CITY OF ALBUQUERQUE

February 17, 2016

**RE: Sandia Area Federal Credit Union-Starbucks
11301 Montgomery NE
Requested for 60 Day Temporary C. O. - Accepted
Engineers Stamp Date 7/1/15 (F22D002)
Certification dated: 12-4-15**

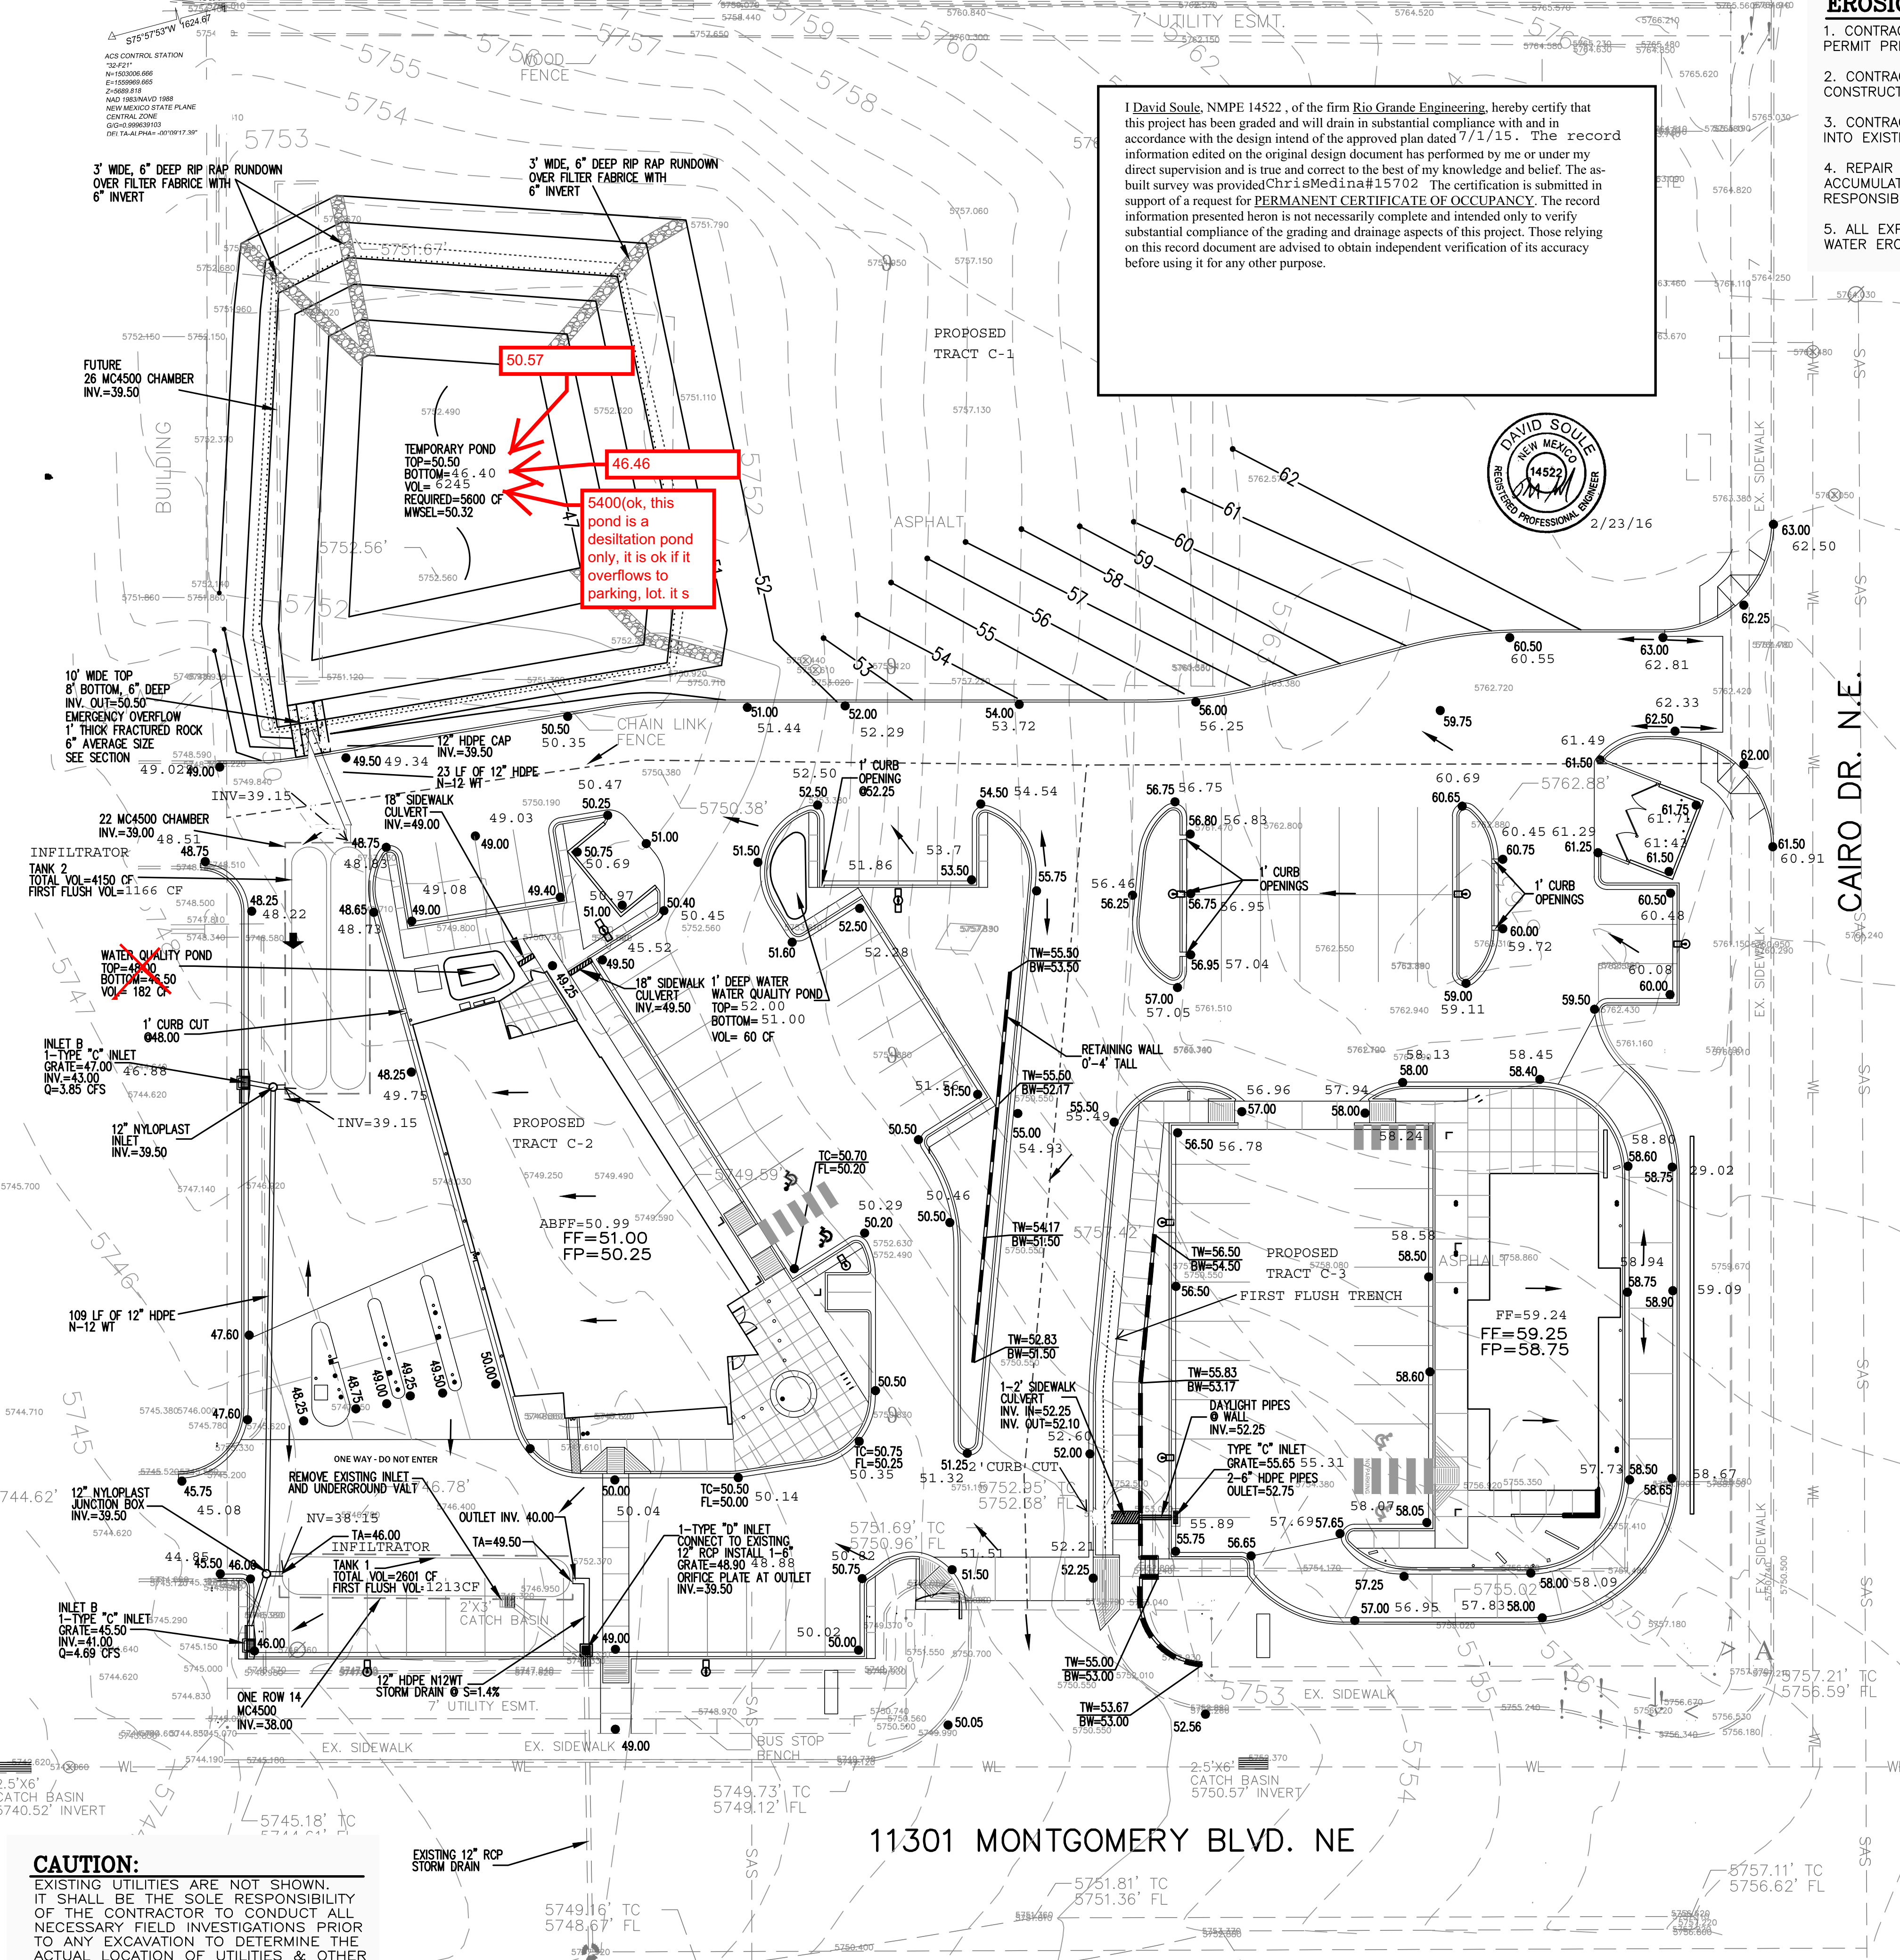
- Provide as-built survey points for the inlets on the Sandia Area Federal Credit Union site.
